Our ref: P18-587-L04v1
24 January 2019

**Re: West Midlands Interchange, Four Ashes :
Comments on Inspection of WMI Noise Study Area**

Following issue of the Hepworth Acoustics Ltd desktop review of the noise chapter (and addendum) of the Environmental Statement on behalf of the Council, an inspection of noise-sensitive areas was made on 21 January 2019 by John Gerring and Wendy Green of South Staffordshire Council and Paul Bassett of Hepworth Acoustics Ltd.

**Section C - CC: Croft Lane East Landscape Cross Section** 1:500 @ A1

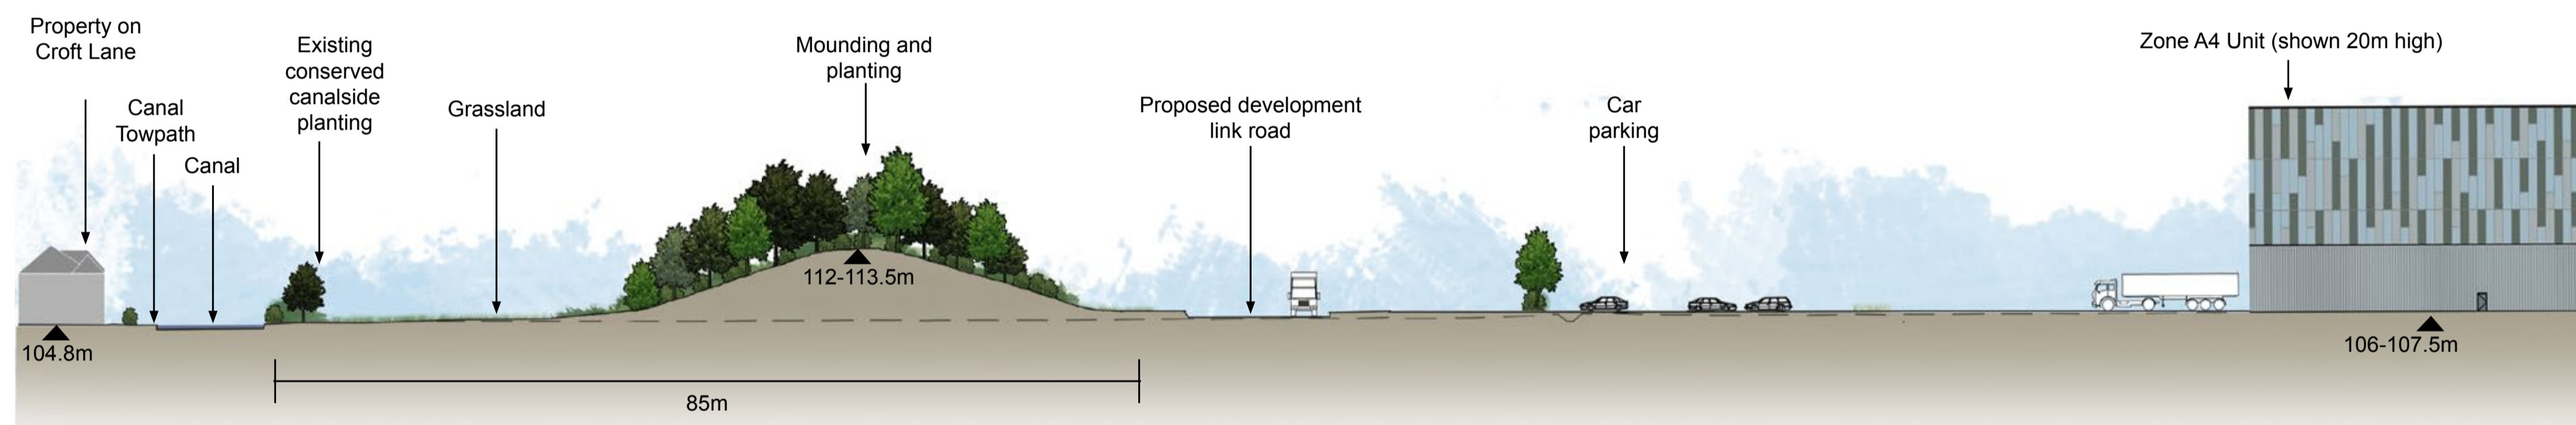
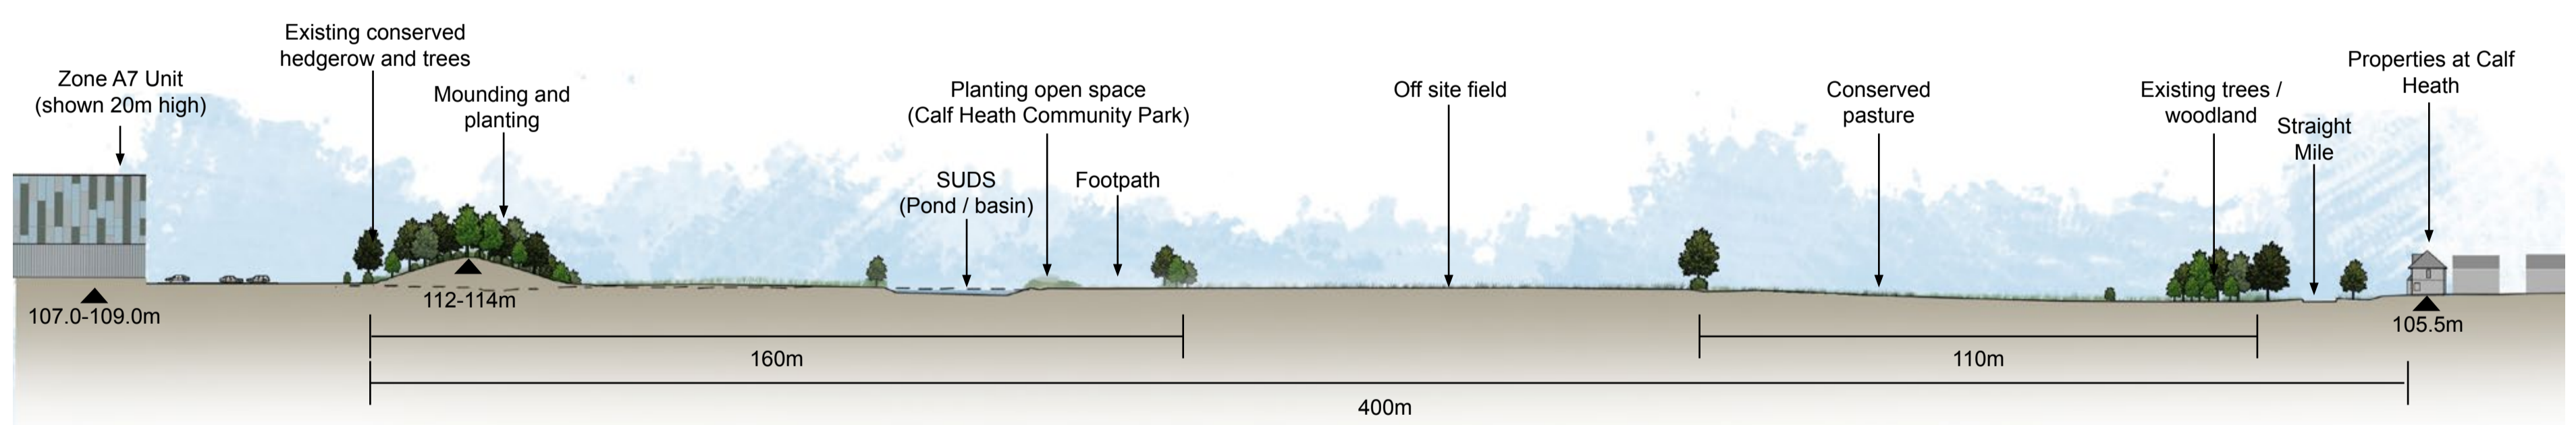
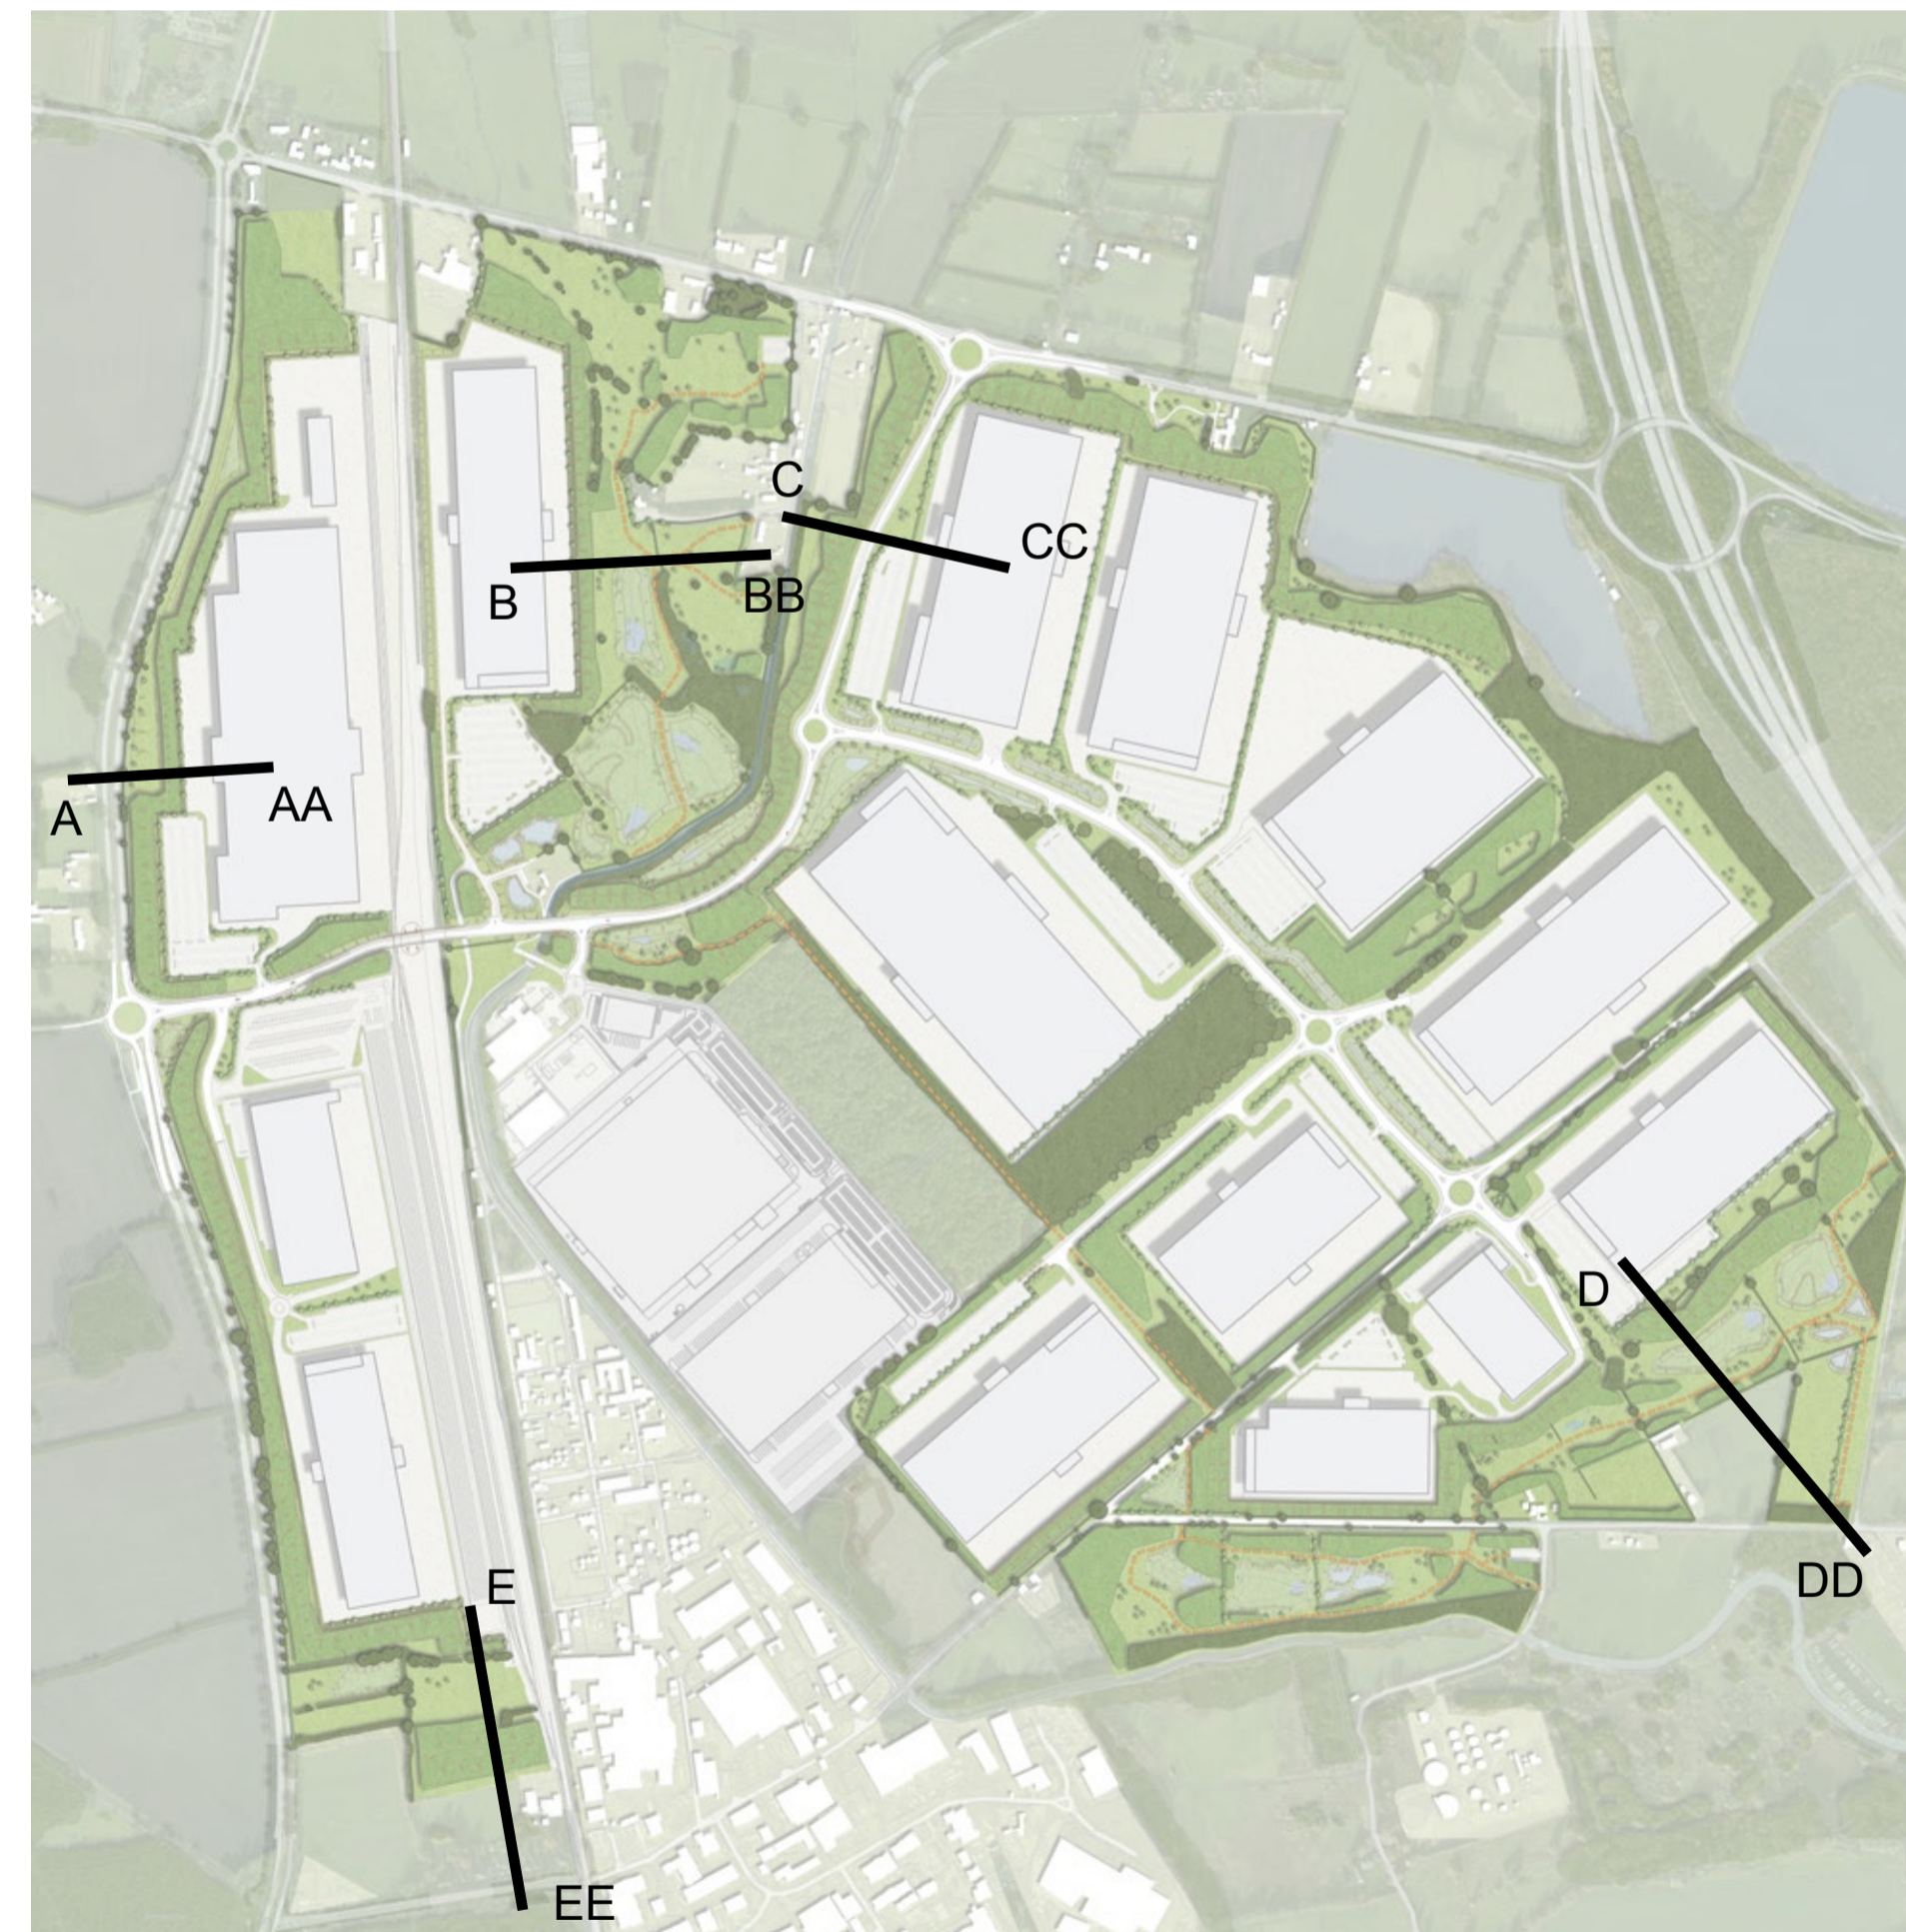
Finally, an inspection was made of the residential area of Croft Lane. This area falls between the proposed development Zone A3 to the west and Zone A4a to the east. The southernmost property next to the canal is Selwyn Green. Other properties nearby include Oak View, The Bungalow, Perinthorpe, Angalia, Allendale, and The Cottage, with housing association properties to the south-west. To the west is Gailey House (we understand that the property further to the west is to be cleared as part of the development). Many of these dwellings are located away from the A5 such that the background noise climate is low. Some properties face east across the canal. The development proposal to the east shown in the masterplan layout includes a main access road from the A5, car parking and the HGV yard on the west side of building 4010. It was noted that Drawing No. 4049-1050-05 shows proposed bunding to the west of the access road but this varies in height from 8m in the north to 6m in the south, with a minimum of 3.5m in the central area. Thus, the proposed noise bund appears to be at its lowest where the majority of houses in Croft Lane are located. Given that most

properties in Croft Lane are predicted in the Environmental Statement to have a BS4142 Rating Level of around +10 dB(A) above the background noise, raising the height of the central area of the bund may be beneficial.

We then viewed the development site from Station Drive and noted the houses and bungalows in Station Drive on the west side of the railway which have rear gardens facing the direction of the southern end of Zone A1. It was noted that bunding of 6m height is proposed immediately adjoining the southernmost building/yards and that a further 8m high bund (and acoustic fencing) is proposed nearer to the southern boundary of the development site. The proximity of the railway and the industrial nature of the land use on the east side of the railway was noted.
